Saffron Lodge
46 Kingsway, PO21 4DN
My Ref: AW/85/18/HH-1

Ref: **OBJECTION** : AW/85/18/HH (54 Kingsway, Craigweil.)

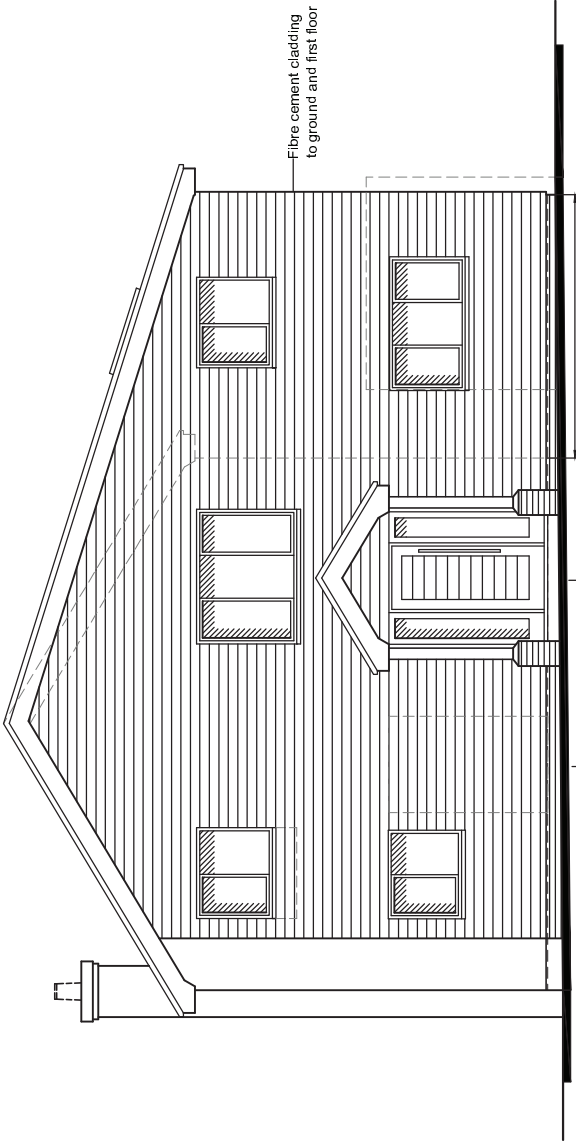
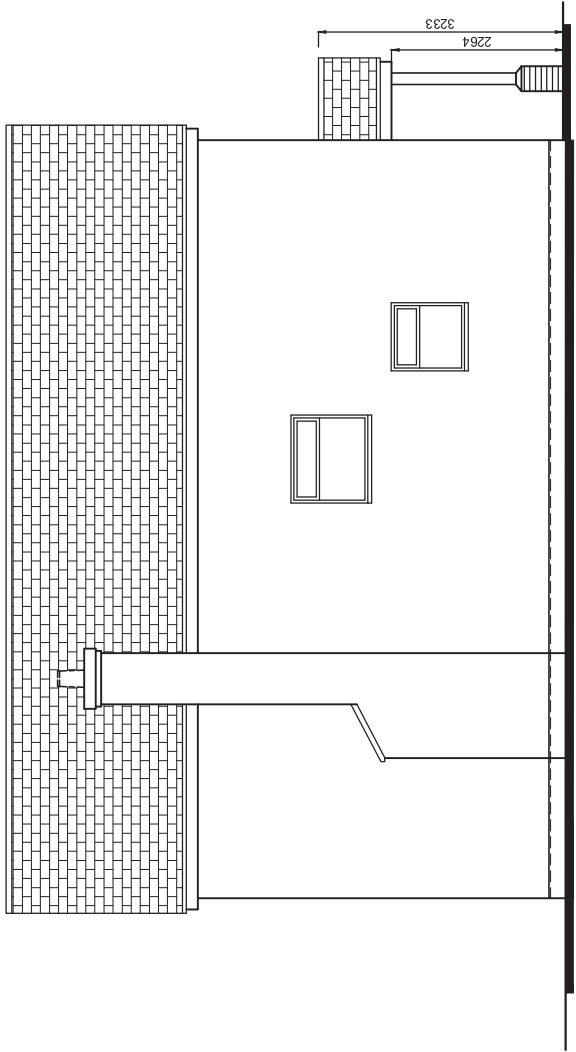
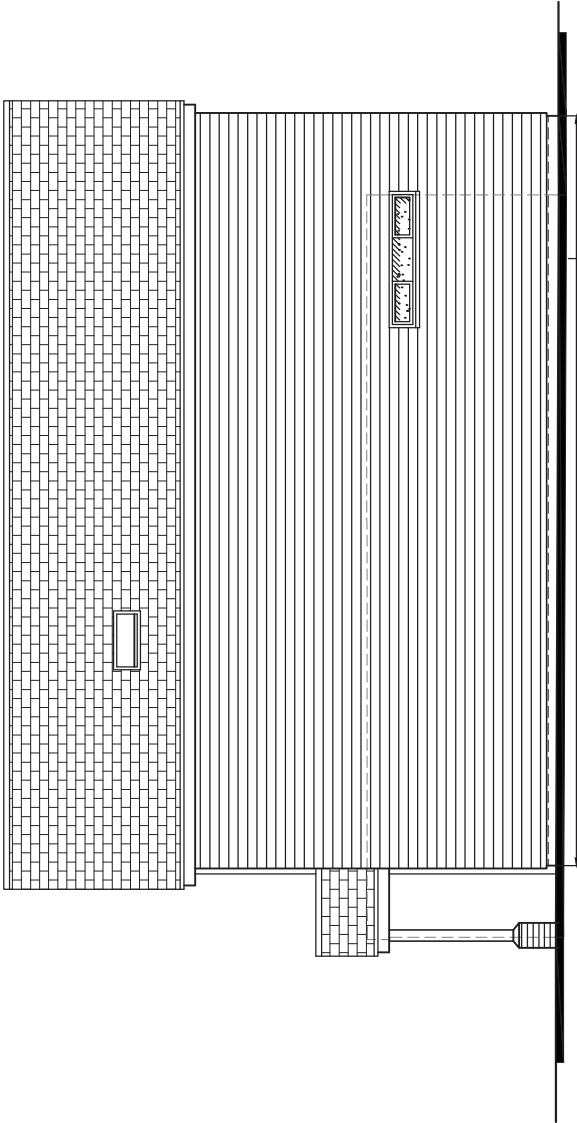
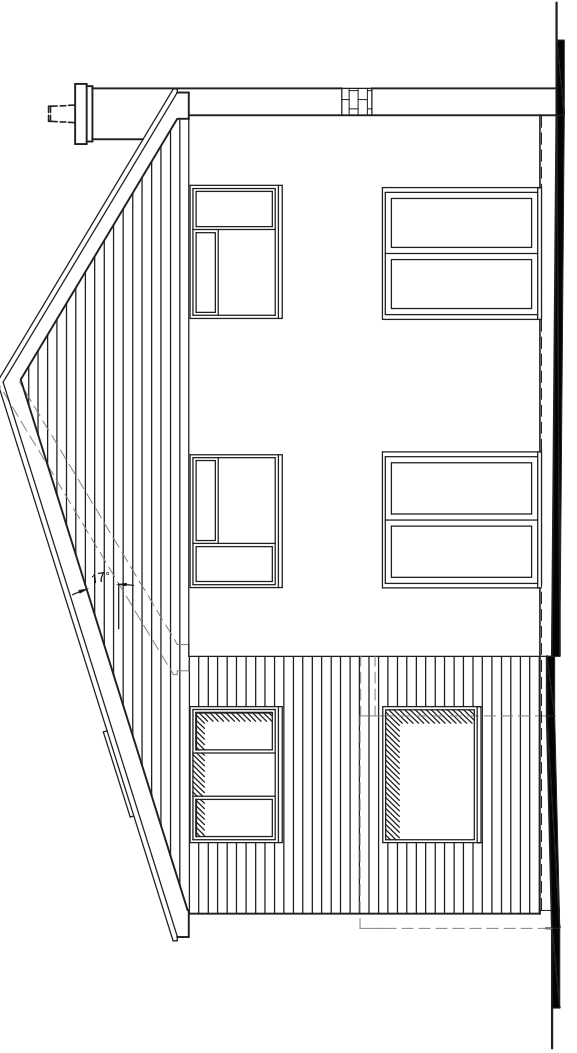
2. **Policy Dev 19** refers to **special awareness** of surrounding buildings. So close to No 52 Kingsway and infilling the space above the garage, it is unsympathetic and compromises the space between property, contrary to the **general** street scene and pattern of development in the CHCA. The drawings give no indication as to closeness, apart from **maybe a 234 MM (9-10") gap on the western elevation..**

3. **At Policy GEN7, (iv)** it says Development; '**does not have an unacceptable adverse impact on adjoining occupiers....**' Then at **(v) Development will be permitted provided it takes account of any unacceptable adverse impacts that may arise from adjoining land uses or property.'** Again clearly, **these proposals have a considerable and unacceptable impact in the immediate area**. All surrounding properties will have a very different outlook to that which exists, reducing the relatively open aspect, into a closed and block effect with the large infill over the replaced ground floor garage space.

5. HER DM3j concerns ‘harming important views into, out of or within the Conservation Area’. Clearly the appearance of the proposed design will be seen from north, east and west directions including maybe Marquis Way, and therefore **it’s block like effect will have, in my opinion, a prominent and adverse effect upon the surrounding area.**

8. Study of the initial Application gave no indication as to the colour of the proposed cladding material, even though **Question 11 specifically requires** details of **type, colour and name of materials** to be recorded. The only colour mentioned is Dark Grey for the roof slates, hopefully not black. The Applicant’s subsequent email at least confirms the colour of the cladding to be Cream/Off White. The query on this was obviously raised due to the Agent/Architect’s omission in Question 11. **Even now, many details from Question 11 are still not recorded.**
